From: [REDACTED]
Cc: [REDACTED]
Subject: RE: TR010027: M42 Junction 6 Improvement - Applegreen plc Deadline 3 Submissions
Date: 15 July 2019 17:16:35
Attachments: [Applegreen DL3 submissions - final.pdf](#)
[Technical Note on Free Flow Junction Alternative for M42 J5a - final.pdf](#)
[Appendices A-E to Applegreens D3 Submissions.zip](#)

DEADLINE 3 SUBMISSIONS

**M42 Junction 6
Development Consent Order Application**

- **Table 1: Comments on the Applicant's responses (Document 8.6) to the Panel's first written questions**
- **Table 2: Comments on the Applicant's Document 8.24: Junction 5A Operational Assessment**
- **Table 3: Comments on the Extra MSA Group's responses to the Panel's first written questions**

**Figure 4 Junction 5A - 2041 Traffic Forecast - Scenario 2**

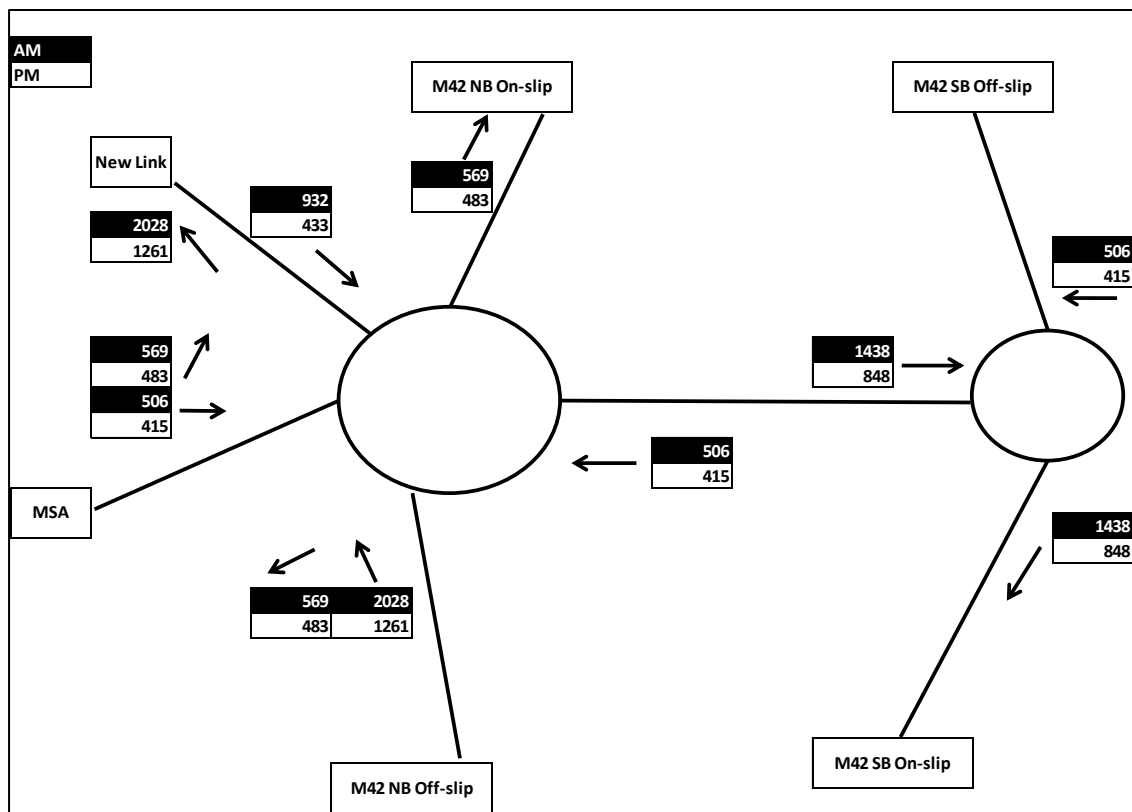
Paragraph	Issue	Applegreen comment
Table 3 & 5.1.9, 5.1.10	Table 3 presents the results of the ARCADY analysis at the western roundabout at Junction 5A in the AM peak with both north and south facing slip roads. The north facing slip roads are required to accommodate the MSA development. The	The results of the modelling at the western roundabout indicate that in the scenario with the MSA, the northbound off-slip would be operating well above capacity. A queue of 159 vehicles is predicted and there is a risk that a queue of this magnitude would extend to affect the M42 mainline. This would have operational and safety consequences both for traffic

Assessment is based on a 6% turn-in rate to the MSA. The analysis indicates that the western roundabout is forecast to experience traffic demands in excess of its capacity on the M42 northbound off-slip approach arm where a ratio of flow to capacity (RFC) of 1.11 is predicted with a corresponding queue of 159 vehicles. The Level of Service (LOS) is rated as F which indicates that the flow has broken down and congestion will occur.	leaving the motorway at Junction 5A and for traffic continuing northbound on the M42 towards Junction 6.
Table 5 & 5.1.12, 5.1.13	To improve the performance of the western roundabout, a further test is undertaken on the basis that a segregated left-turn lane from the northbound off-slip directly into the MSA is provided. This is shown to improve the performance of the western roundabout where a maximum RFC of 0.87 and corresponding queue of six vehicles is predicted on the northbound off-slip during the AM peak.	At roundabouts, a maximum desirable RFC value of 0.85 is preferred as this minimises the chance of queues forming at the junction and therefore builds in some resilience to the design. The RFC on the northbound off-slip even with the left-turn lane to the MSA, exceeds the 0.85 RFC threshold and is an indication that the northbound off-slip is beginning to show signs of stress with an increasing likelihood of queues forming.

**Figure 5 Junction 5A - 2041 Traffic Forecast - Scenario (MSA 8%)**

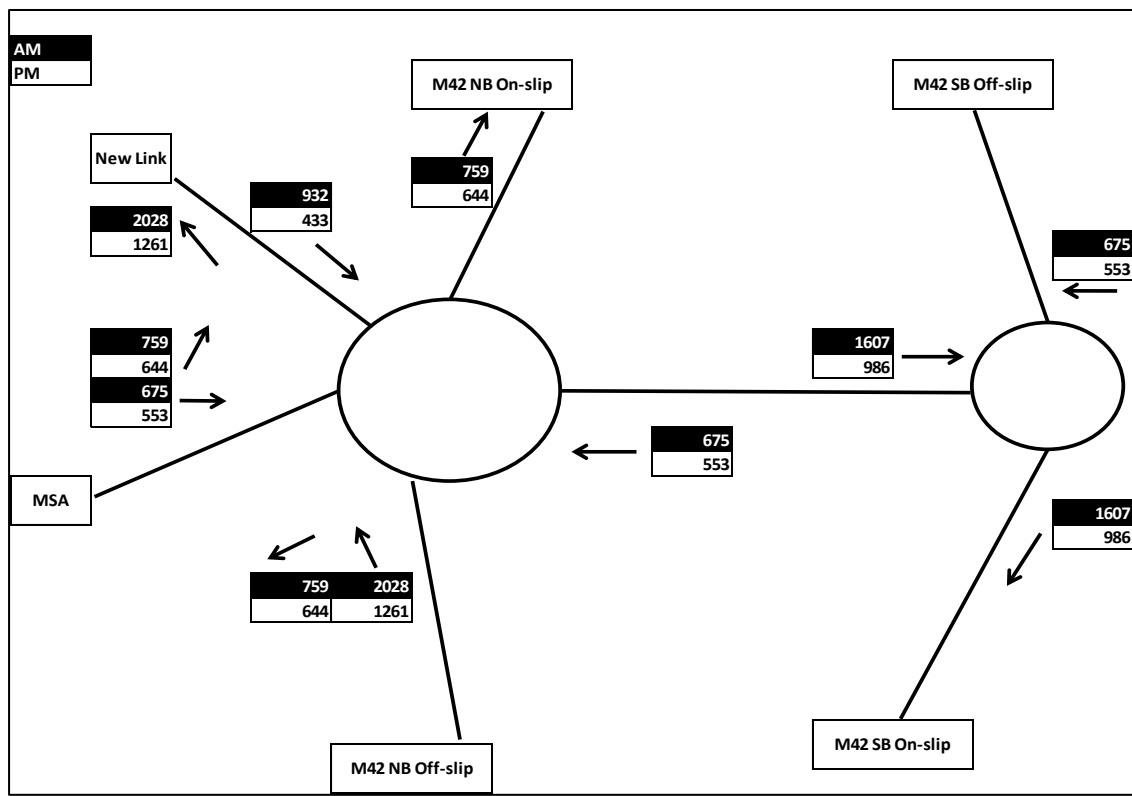
Table 6 & 5.1.14, 5.1.15, 5.1.16	The above exercise was repeated with an 8% turn-in rate which was undertaken by the Applicant for the MSA development as a sensitivity test.	The results of the ARCADY assessment indicate that even with the segregated left turn lane into the MSA, the western roundabout would operate above capacity. The critical arm is the exit from the MSA where a RFC of 1.05 and a queue of 48 vehicles is predicted during the AM peak. On the northbound off-slip a RFC of 0.91 and a queue of 10 vehicles is predicted also during the AM peak. As noted above this exceeds the 0.85 RFC threshold and is an indication that the northbound off-slip is beginning to show signs of stress with an increasing likelihood of queues forming.
Table 7 & 5.1.17 to 5.1.25	Acknowledging the capacity issues at the western roundabout, Highways England has proposed a further capacity improvement involving widening and partial signalisation. The proposal is to provide traffic signals on the northbound off slip and the MSA exit arm and to widen on the northbound off-slip and on the western circulatory section of the	The modelling results presented in Table 7 indicate that the western junction would operate within capacity with a maximum DoS of 85% and queue of 14 passenger car units (pcu's) on the MSA exit arm during the AM peak. The corresponding values for the northbound off-slip are 81% and 12 pcu's. No modelling output has been provided by the Applicant. An observation of the proposed design is that there is a very short stacking length on the circulatory approach carriageway to the MSA exit. If a HGV was to be stopped at a red

**Figure 6 Junction 5A Proposed Design - With MSA**

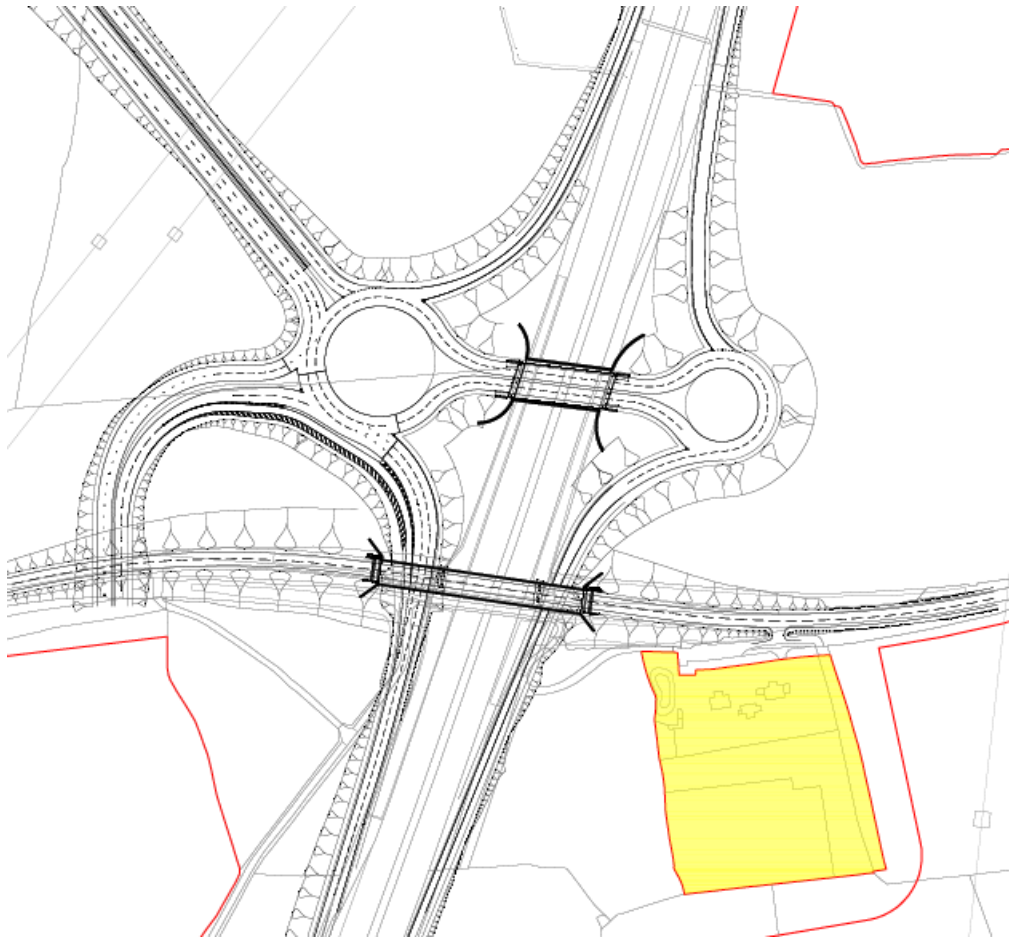
<p>roundabout. The exit onto the new dual carriageway link would also be widened to 3 lanes allowing traffic to merge from three to two lanes downstream of the junction. The segregated left turn lane into the MSA would be retained.</p> <p>The proposed layout has been modelled on the basis of an 8% turn-in rate using LinSig. The critical outputs from LinSig are the degree of saturation (DoS) for each individual link and the practical reserve capacity (PRC) for the junction as a whole. The maximum desirable DoS/PRC is 90% and if this is exceeded the junction begins to become unstable with an increasing likelihood of queues forming.</p>	<p>signal on the circulatory carriageway, there is a risk that it would block the entry to the MSA which would have implications for the operation and safety of the junction. Highways England has not provided the output from the LinSig analysis and therefore it is not possible to establish whether queues would form on the short section of circulatory carriageway at the access to the MSA.</p> <p>A further observation is that for consistency it is considered that the junction should be modelled using microsimulation rather than a static traffic model such as LinSig. In its response to the planning application for an alternative MSA at Junction 4 of the MSA, Highways England rejected the use of a TRANSYT traffic model (which is similar to LinSig) in favour of microsimulation, as the former “is not capable of considering the complex interaction of traffic flows with the M42 mainline”. Highways England’s response identified further limitations of TRANSYT stating that “a matter of particular concern at this junction is further to the interaction of this traffic flow with the M42 Smart Motorway system”. Another limitation that was highlighted was that TRANSYT “is not capable of modelling impacts between individual highway links where congestion may cause queuing traffic to ‘block back’ from one link to the next”.</p> <p>Many of the comments regarding the limitations of the TRANSYT model developed at Junction 4 of the M42 equally apply to LinSig; and on this basis it is considered that microsimulation should have been used to assess the impact of the MSA at Junction 5A. The justification for this is enhanced by the fact that with all the modifications proposed to accommodate the MSA, the junction is becoming more complex with multiple entry lanes, short sections of circulatory carriageway and a short merging section downstream of the junction on the new dual carriageway link road.</p>

<p>6.1.1 & 6.1.2</p>	<p>So as not to preclude the MSA should it receive planning permission at a later date, Highways England is proposing to make a change to the design of Junction 5A. The change is required to accommodate the segregated left turn lane into the MSA which would extend the span of the Solihull Road overbridge by approximately 6m.</p>	<p>Extending the Solihull Road bridge span by approximately 6m would have a detrimental impact on the ancient woodland on the west side of the motorway.</p>
<p>General</p>	<p>The Junction 5A Proposed Design – With MSA as shown in Figure 6 of the Applicants Document</p>	<p>As part of Applegreen's proposal for an alternative MSA at Junction 4 of the M42, the highway scheme that is proposed to accommodate the MSA has been subject to a rigorous</p>

8.24: Junction 5A Operational Assessment has not been subject to a Stage One Safety Audit.	Stage 1 Road Safety Audit in accordance with GG 119. For consistency and to ensure that the scheme shown in Figure 6 provides a safe solution, it should be subject to the same rigorous process.
General	The Junction 5A Proposed Design – The proposed dumb bell layout introduces unnecessary delays to the majority of the vehicles using the junction.	<p>The dumb bell arrangement will require vehicles travelling from the M42 northbound to the new link road to slow down for the give-way line at the western roundabout and to negotiate the roundabout before proceeding along the link road. The free flow arrangement would allow them to make this movement without these delays.</p> <p>The dumb bell arrangement will require vehicles travelling from the new link road to the M42 southbound to slow down for the give-way line at the western roundabout and to negotiate the roundabout before proceeding to the eastern roundabout to negotiate the give-way line and the roundabout before joining the motorway. The free flow arrangement would allow them to make this movement without these delays.</p> <p>Every vehicle making these movements would incur these delays. Over the course of a year this would add up to significant unnecessary additional delay.</p> <p>If the MSA were constructed these delays would be significantly greater. As the Applicant has not provided copies of the junction modelling it is not possible to quantify these delays.</p>
